WEST SUSSEX COUNTY COUNCIL CONSULTATION

TO:	Arun District Council FAO: Simon Davis
FROM:	WSCC - Highways Authority
DATE:	27 May 2022
LOCATION:	Salisbury House The Steyne Bognor Regis PO21 1TX
SUBJECT:	BR/63/22/PL Change of use of 5 No self-contained flats for adults with learning difficulties to 5 No self-contained flats and formation of 5 No further flats from HMO rooms, garage and office, repairs and decoration of external surfaces, minor alterations to elevation facing Sadler Street, change one window facing rear courtyard to French doors & apply obscure film to 2 windows in courtyard area. This application affects the setting of listed buildings, affects the character & appearance of The Steyne Conservation Area and is in CIL Zone 4 (Zero Rated) as flats.
DATE OF SITE VISIT:	n/a
RECOMMENDATION:	Advice
S106 CONTRIBUTION TOTAL:	n/a

GROUND FLOOR

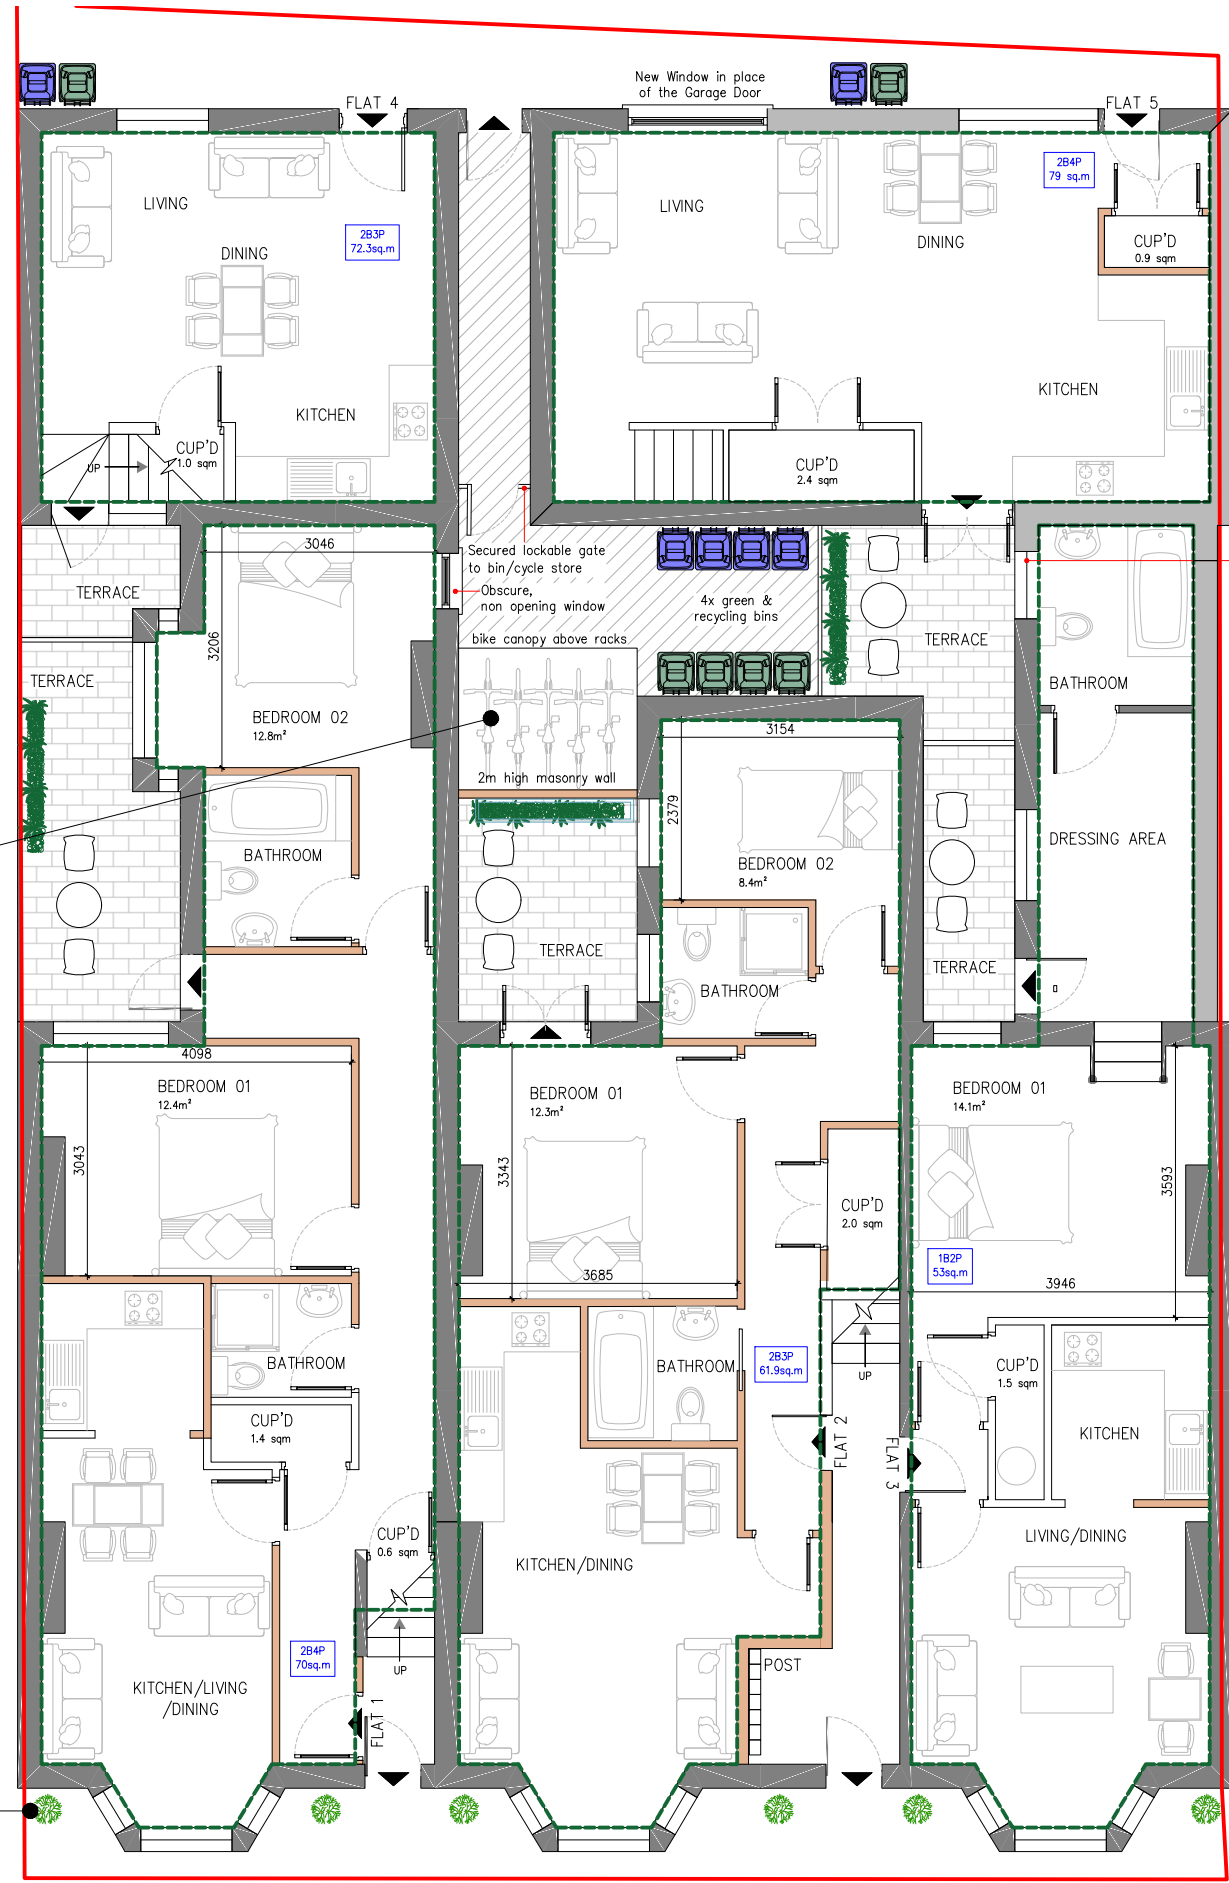
The proposal will result in the loss of the existing single garage to the rear of the site. A nil parking provision is proposed for the new development. Under the Arun Car Parking SPD, 11 car parking spaces may be provided for the proposal. However, under the existing arrangements, the use of the site could generate a parking demand of a minimum of 8 parking spaces; seven of which would have been required to be accommodated on street. As such, this proposal has the potential to result in an additional on-street parking demand of 3 spaces. Whilst on-street car parking is limited in the immediate vicinity there are comprehensive parking restrictions prohibiting vehicles from parking in places that would be detrimental to highway safety. We would not consider that highway safety would be detrimentally affected through the proposed nil car parking provision. The Planning Authority may wish to consider the potential impacts of this development on on-street car parking from an amenity point of view.

The site is sustainably located within the centre of Bognor Regis, within proximity to a variety of local shops, services and public transport links which reduce the reliance upon the private car. Cycle storage is proposed for up to 10 cycles within a two-storey racking system. Whilst the LHA acknowledge that this is not the most convenient storage solution for residents; given the site constraints and that the racks will be covered and the cycle/bin store area will be secure, the LHA would accept the proposed arrangements.

No part of the development shall be first occupied until covered and secure cycle parking spaces have been provided in accordance with the proposed plan.
